facsimile transmittal

To: Mark Chaloupecky **From:** Mike Nugent

Re: 157 York St.

STAIR SECTIONS

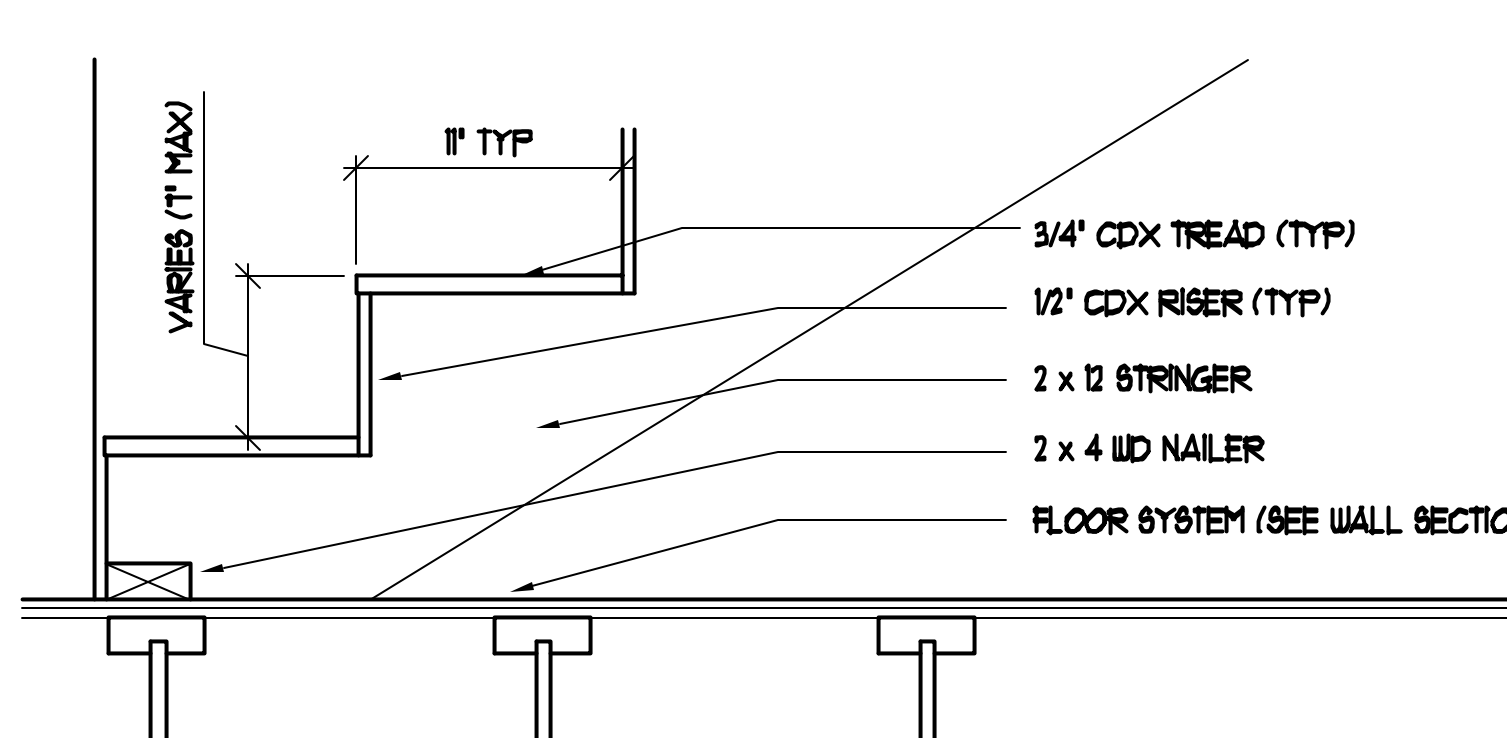
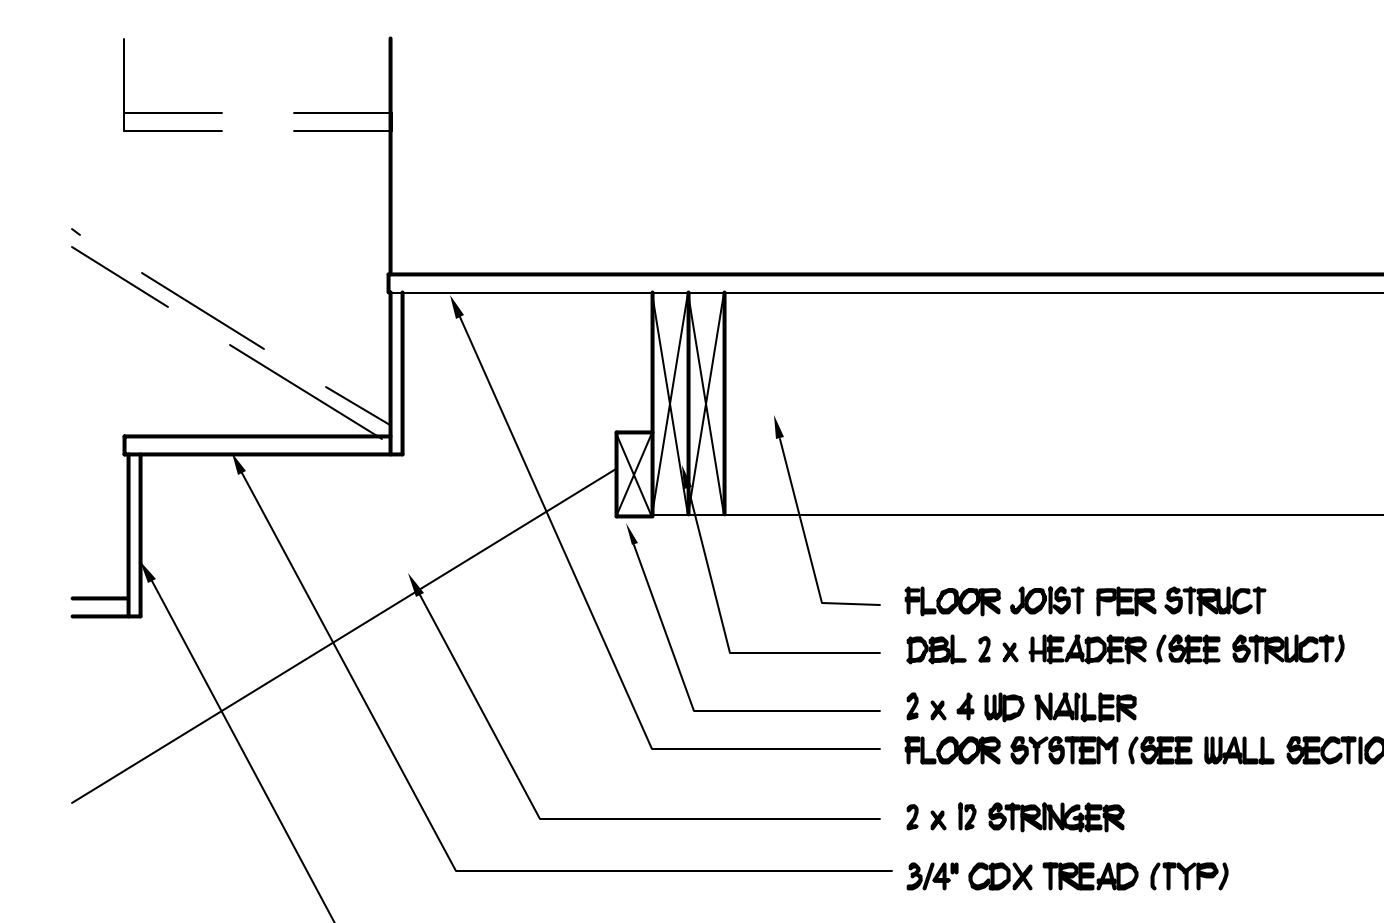
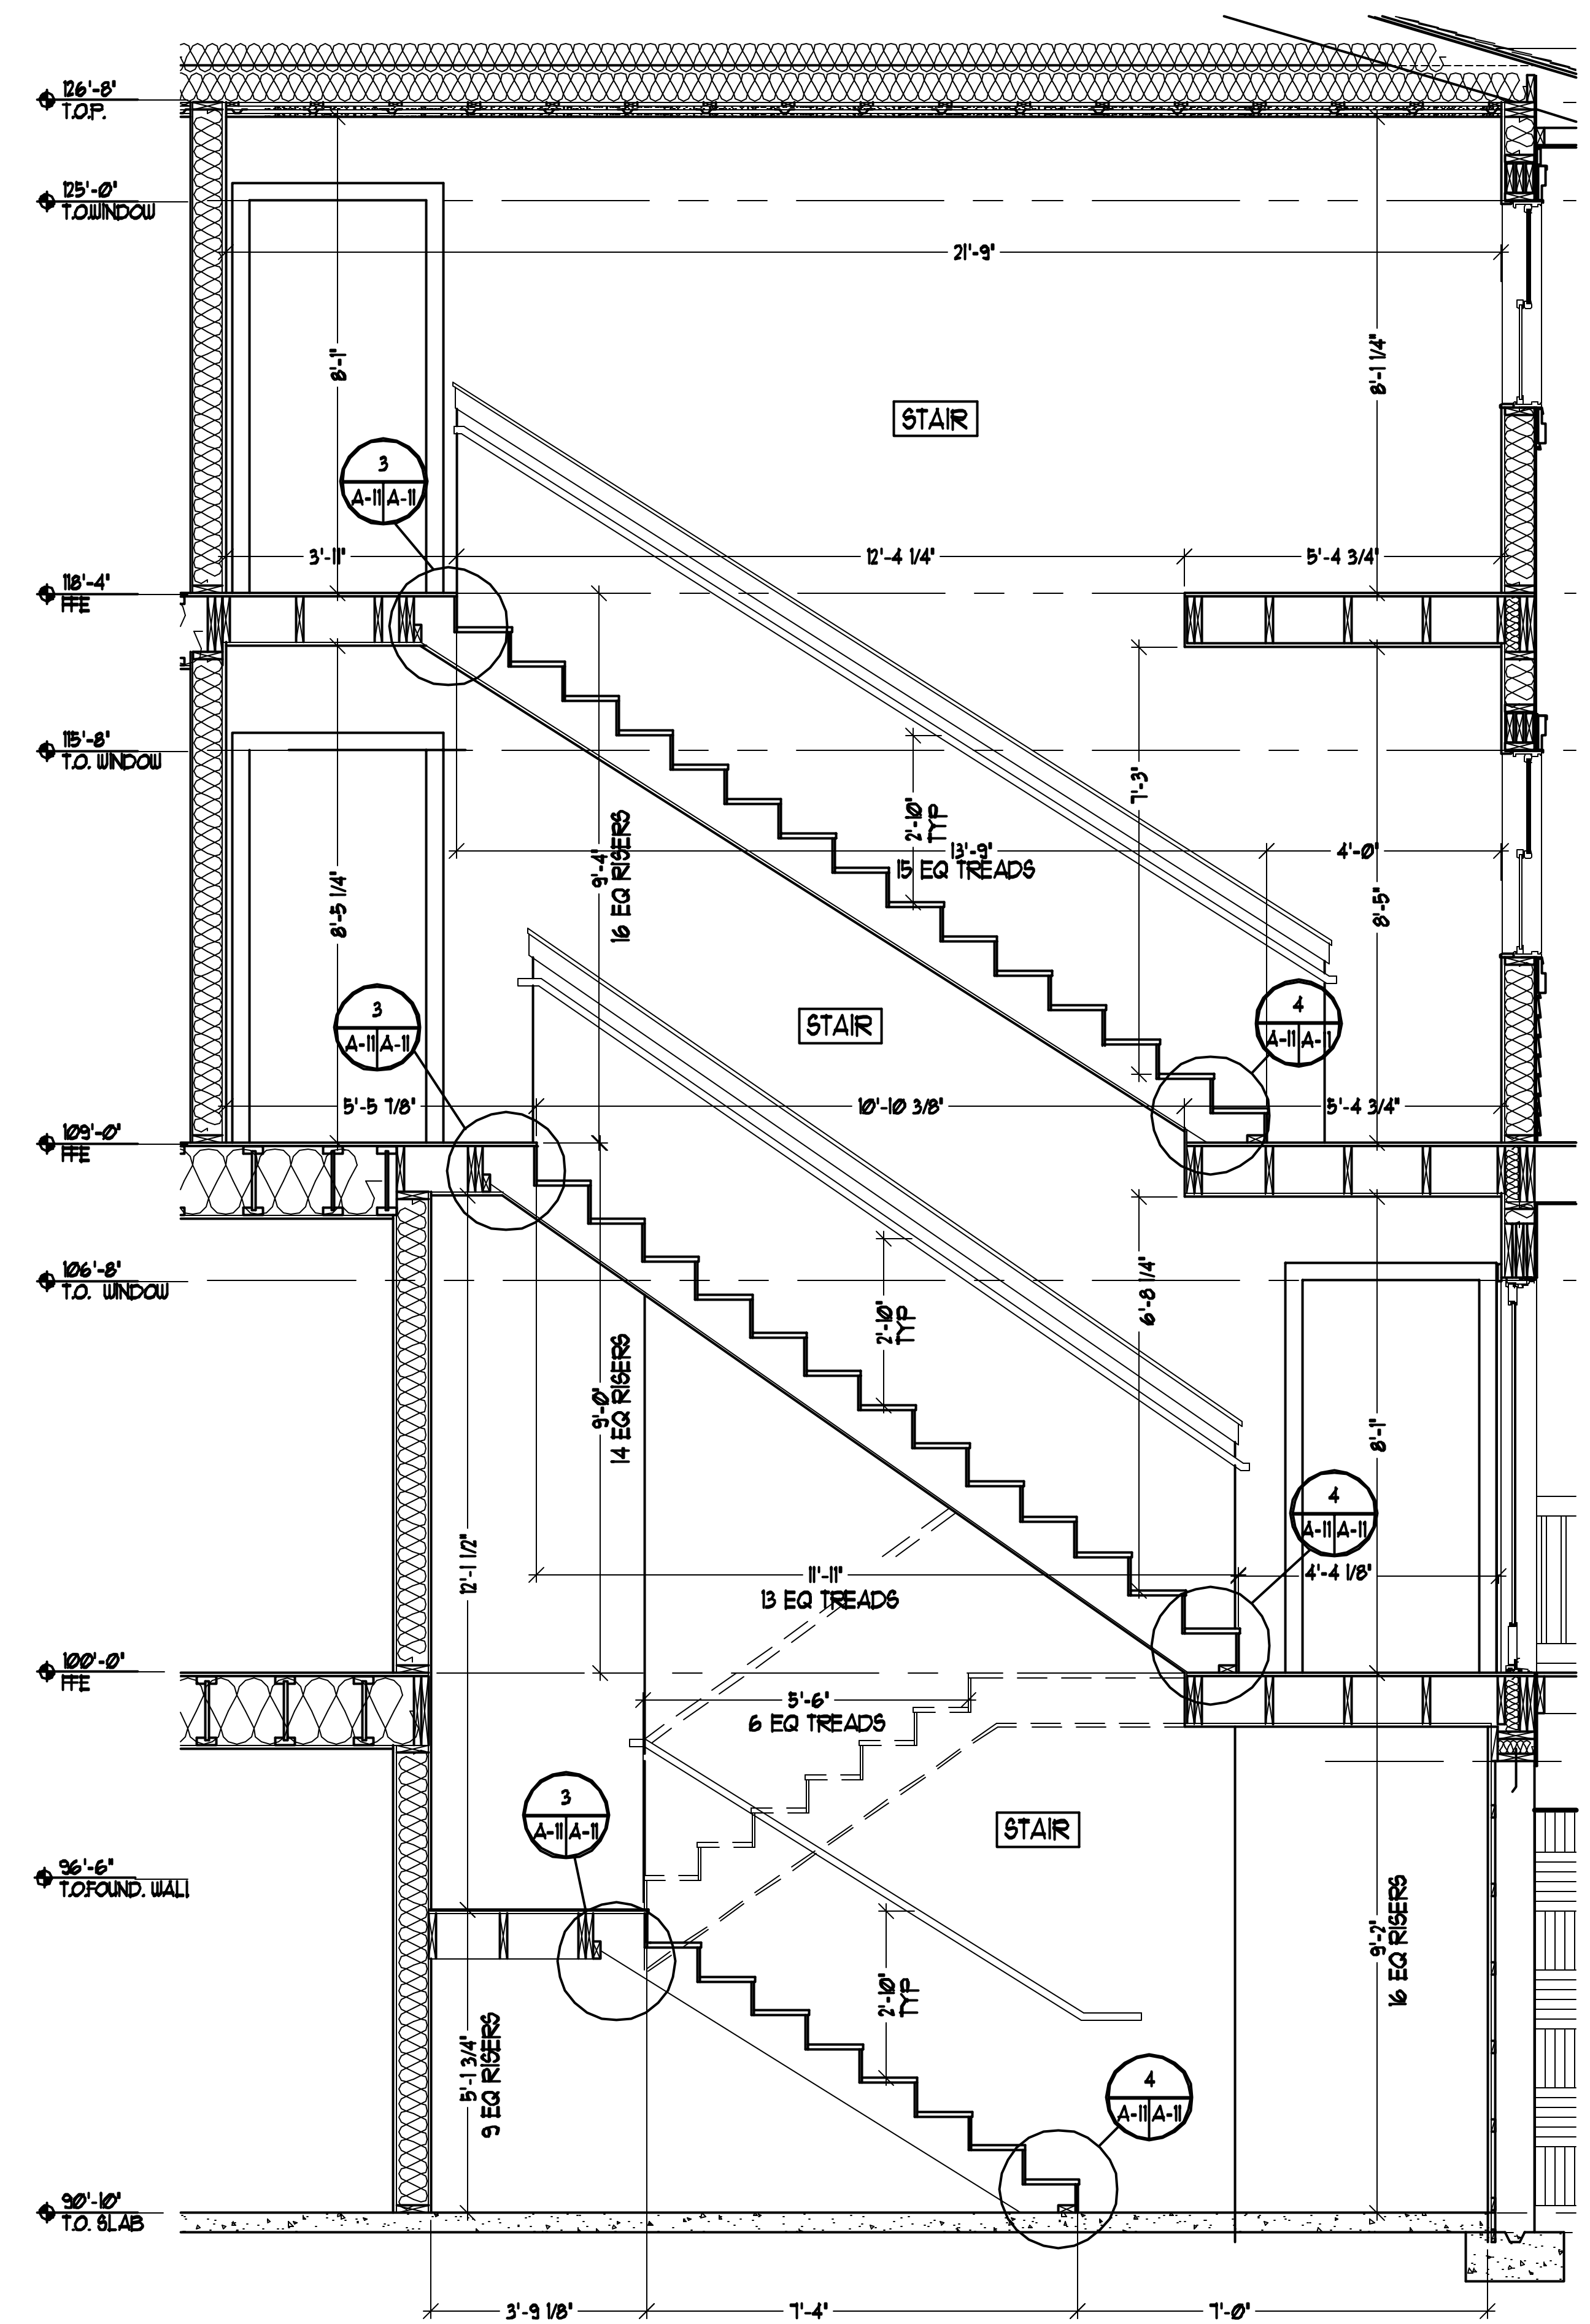
5) Section 1014.12 requires that exterior stairways and landings be protected from the
accumulation of ice and snow, Compliance with this a requirement is not reflected.
